Description: Proposed distributor road.

Location: Land off & to north of Monks
House Lane
Spalding
Lincs

Amendment: Proposed re-alignment of road and amended junction with
Meadway (Dwg. No. 98024/001 Rev A & 98024/002)

ACKNOWLEDGEMENT OF AMENDMENT

98024/002

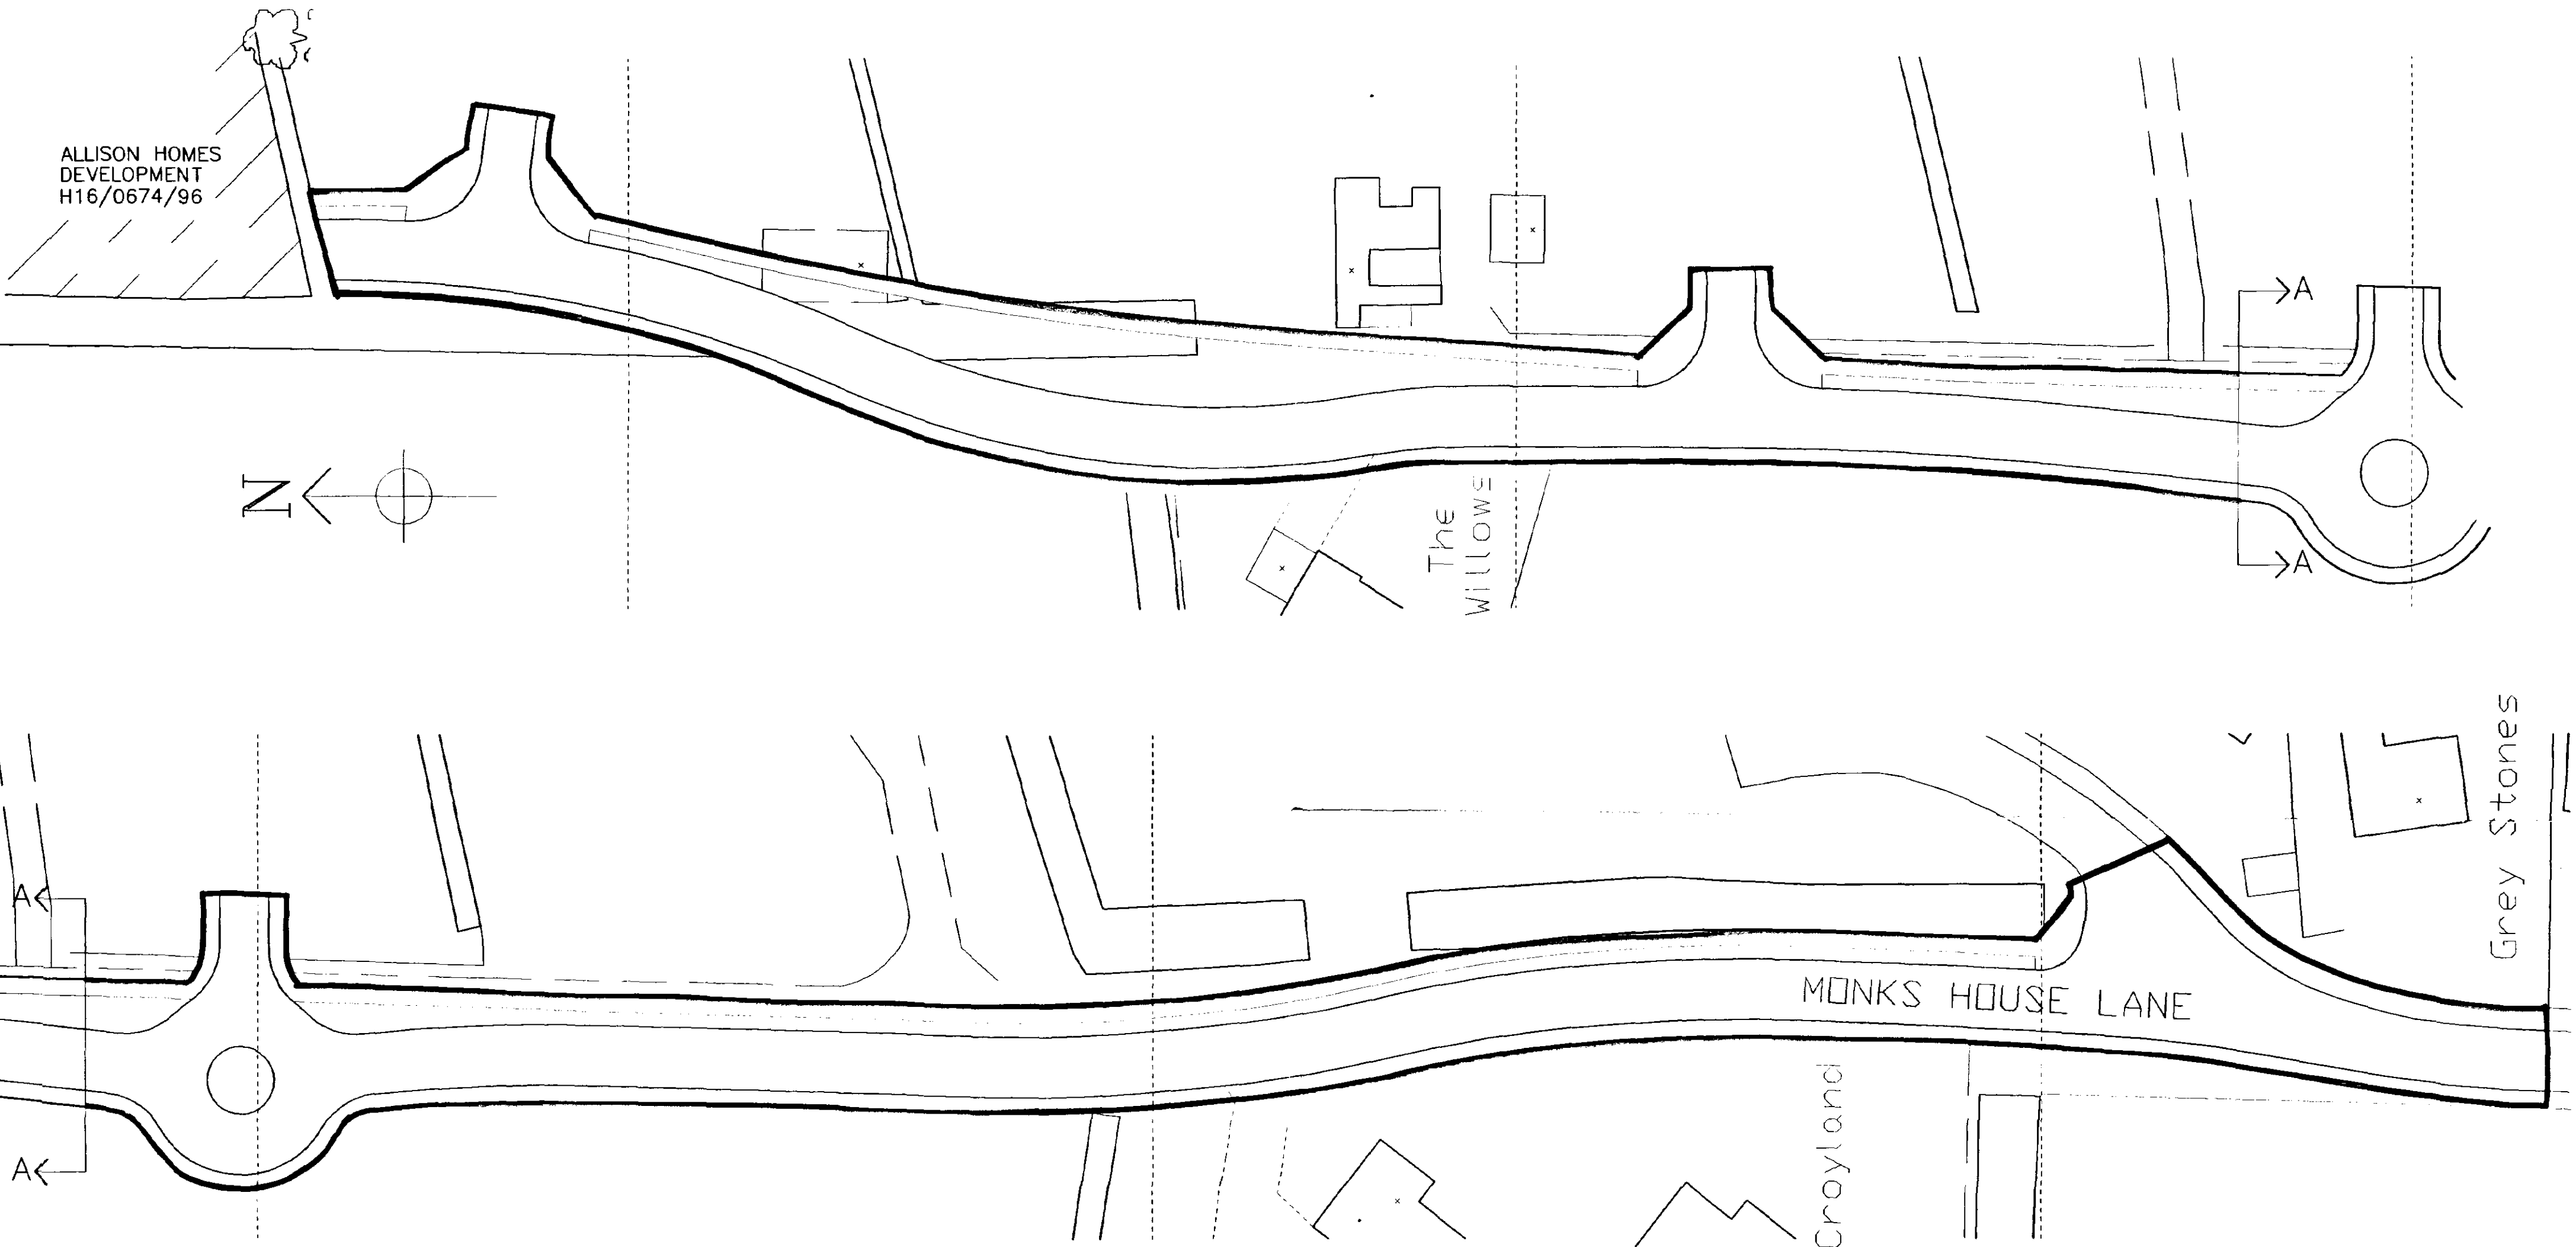
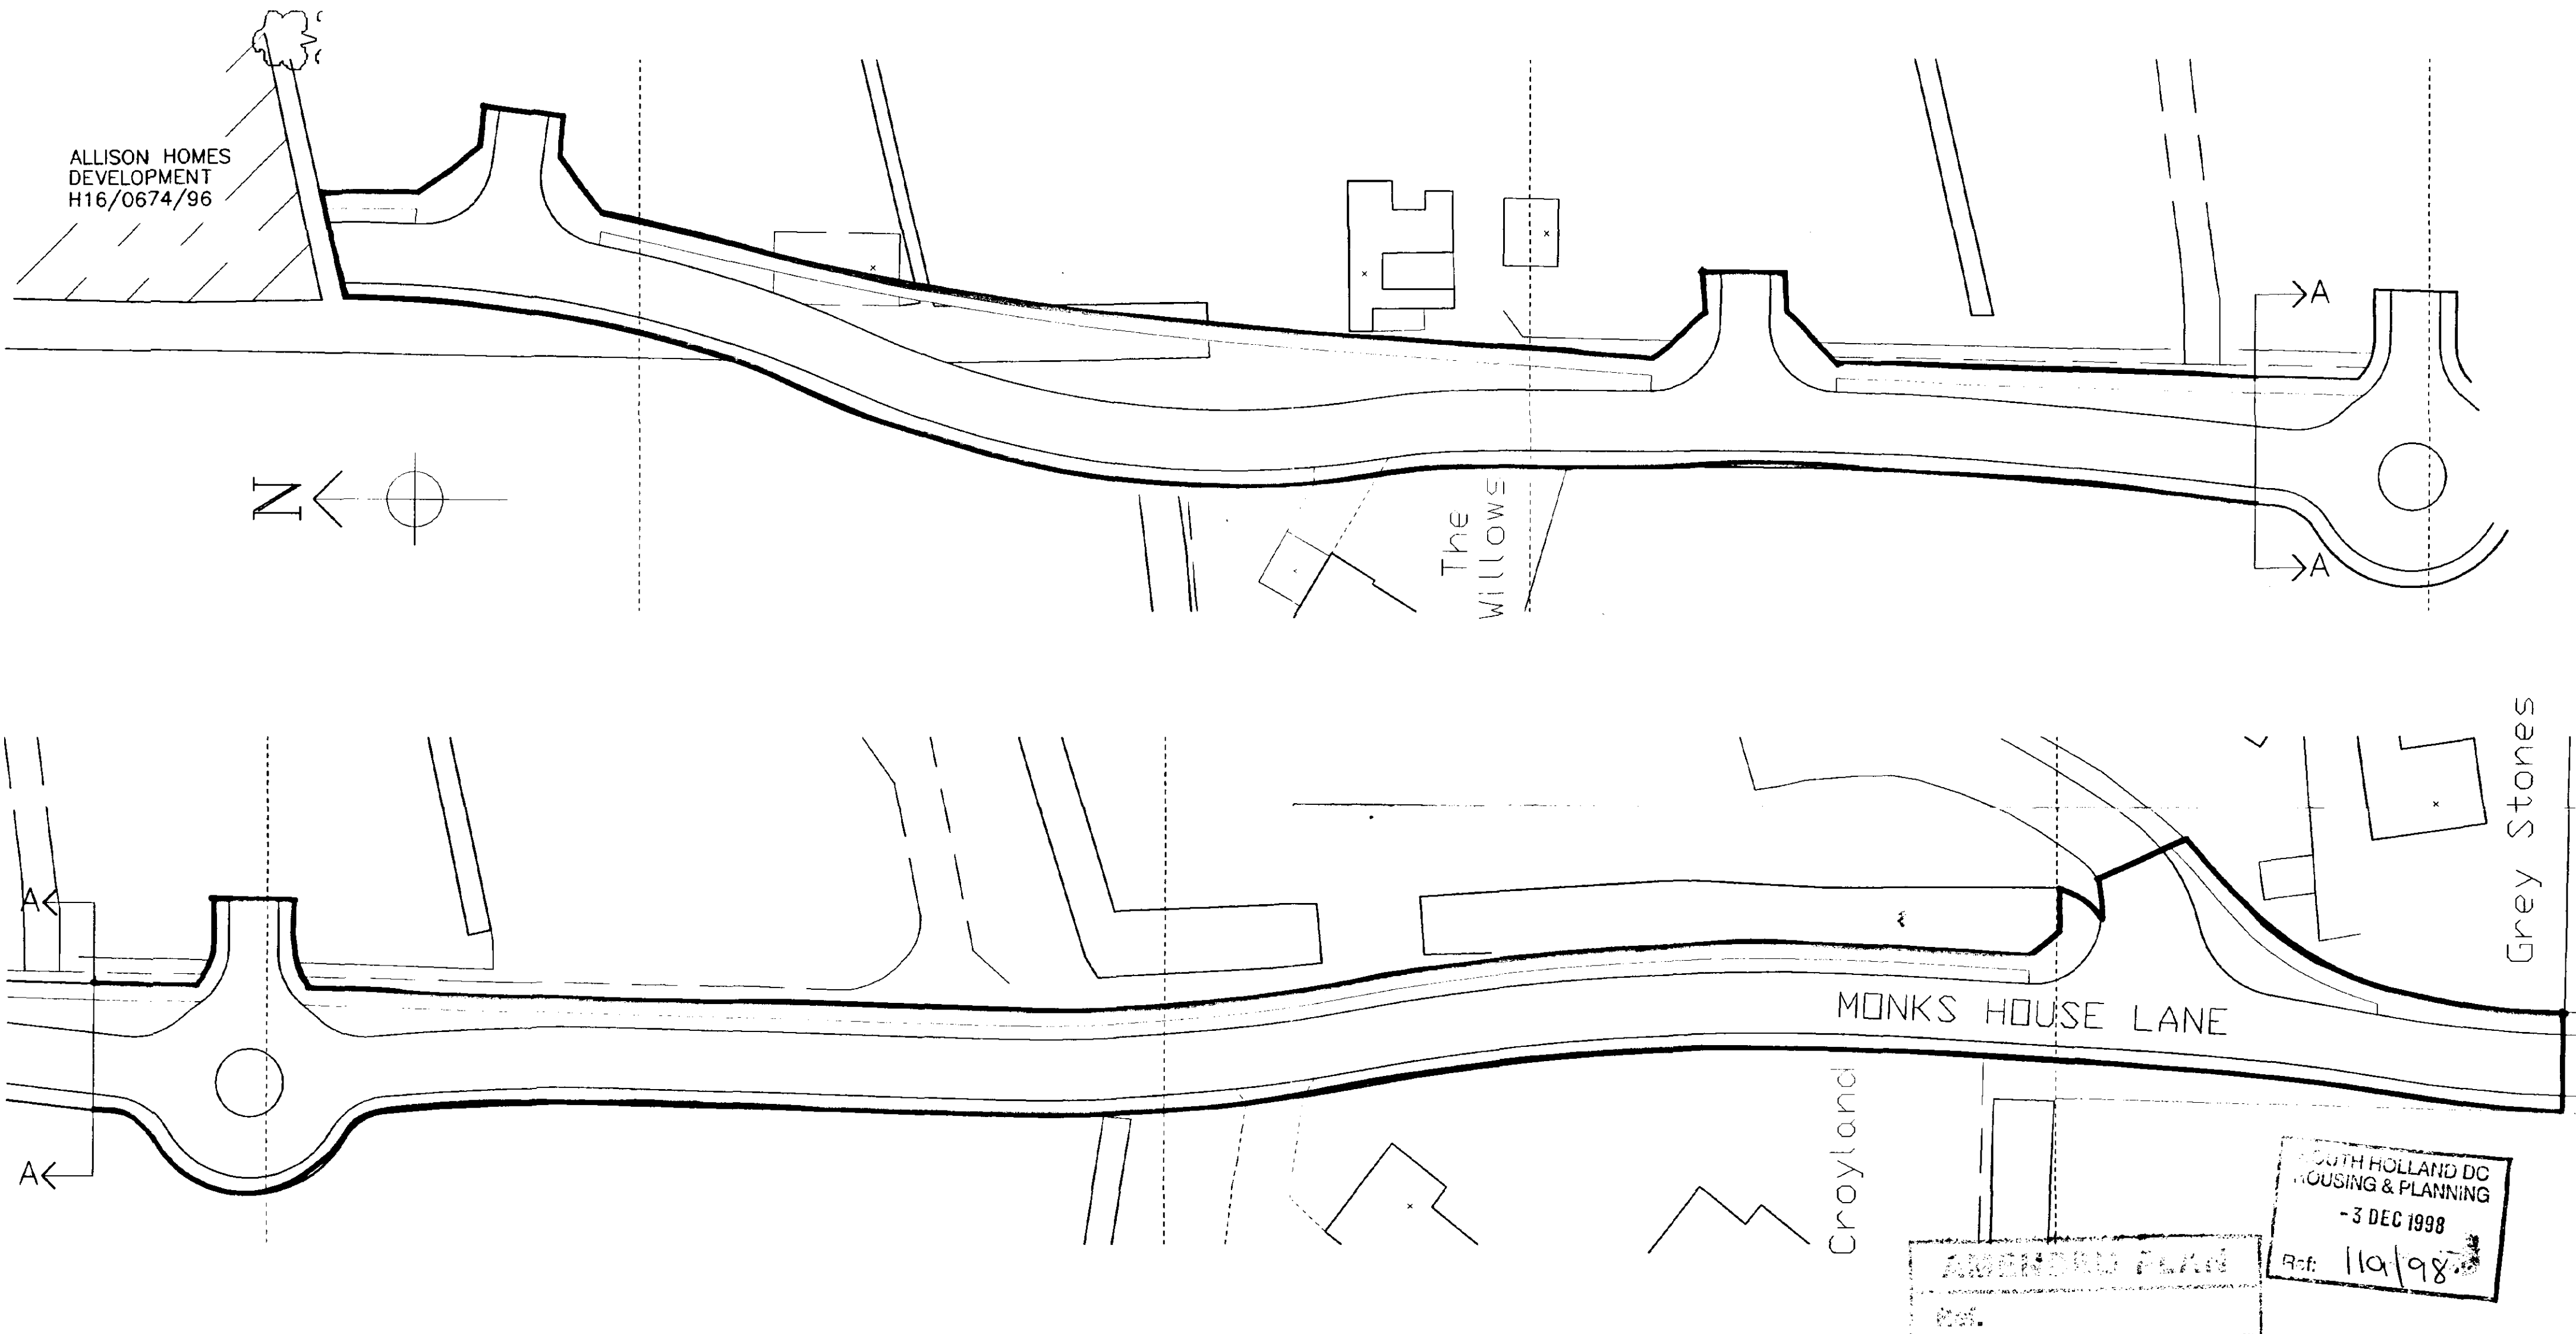
PROPOSED RE-ALIGNMENT OF ROAD
AND AMENDED JUNCTION WITH
MEADWAY.

AS REQUESTED BY L.C.C. HIGHWAYS
